KITITAS COUNTY

MEMORANDUM

TO: All Staff
FROM: Justin Turnbull, County Surveyor 
DATE: November 15, 2017
SUBJECT: County Survey review of Boundary Line Adjustment 17-00017 (Jensvold)

SHEET 1 OF 2

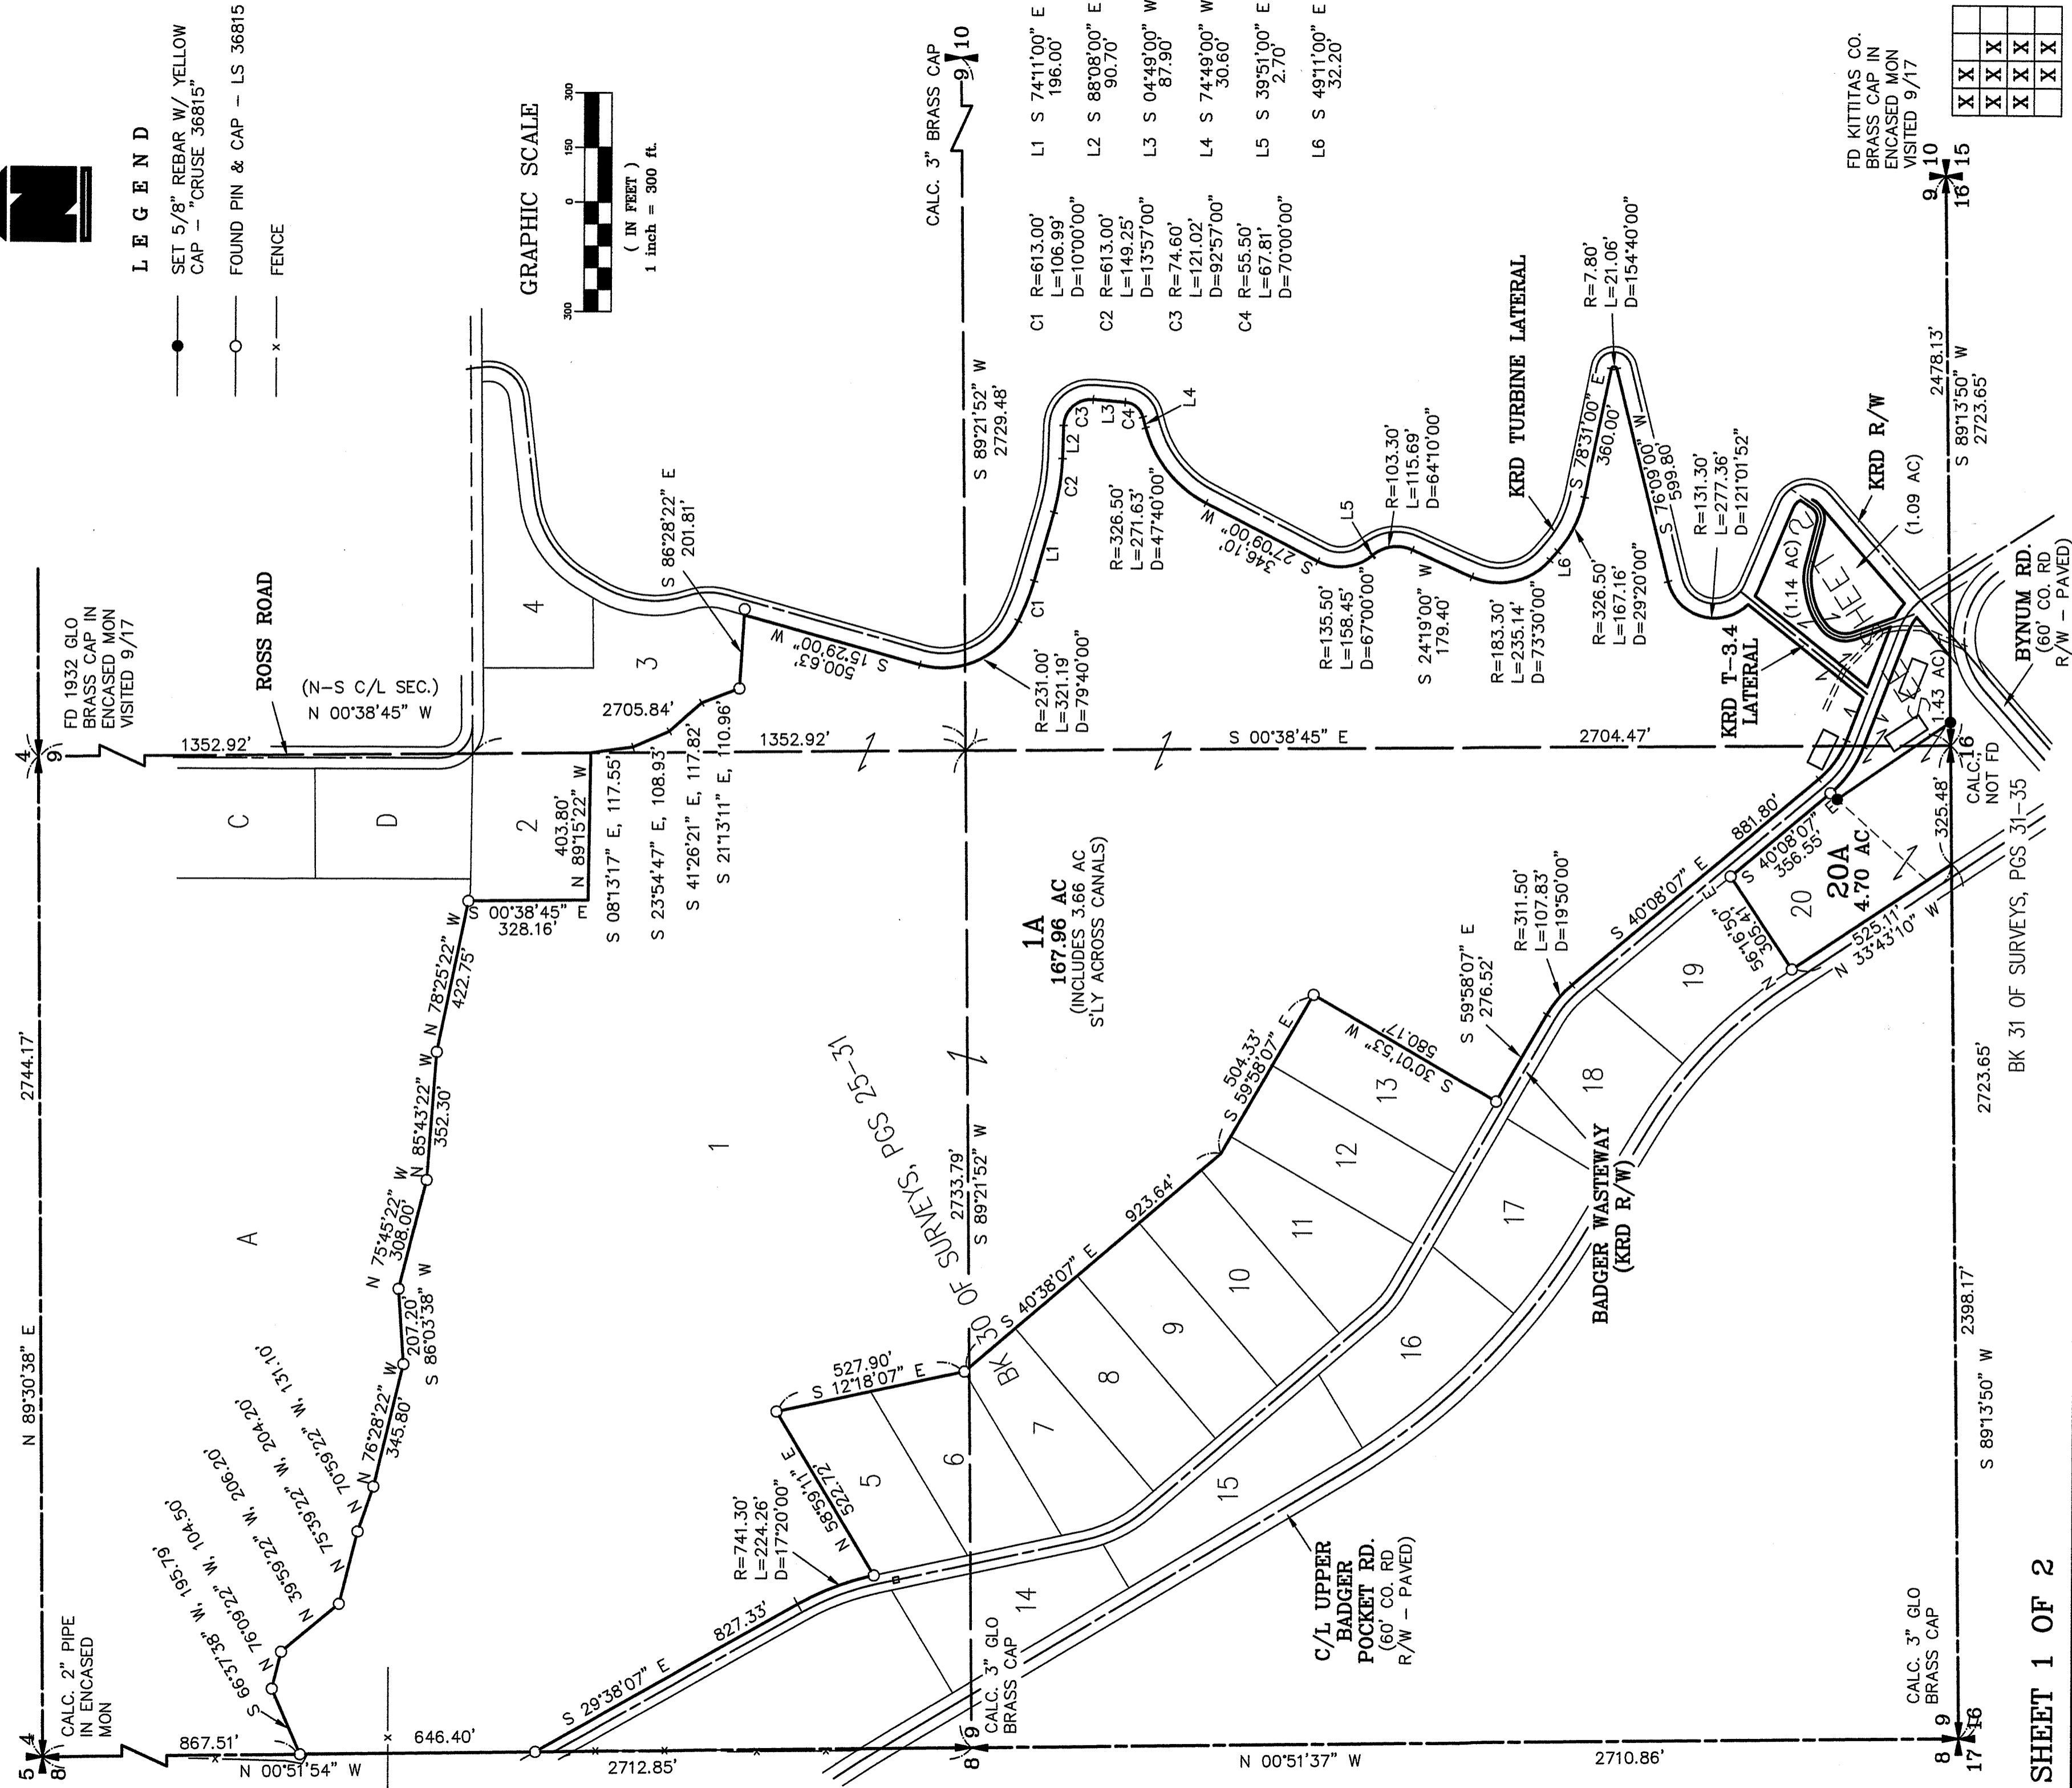
1. A purpose of survey statement, together with the application number should be included in the notes.
2. The previous boundary (or existing boundary) should be labeled.
3. Land Corner records should be noted as follows:
 - N1/4: LCR 201705190002
 - NW: LCR 201705190027
 - SW: LCR 199603290022
 - S1/4: LCR 199603290024
 - SE: LCR 201705190016
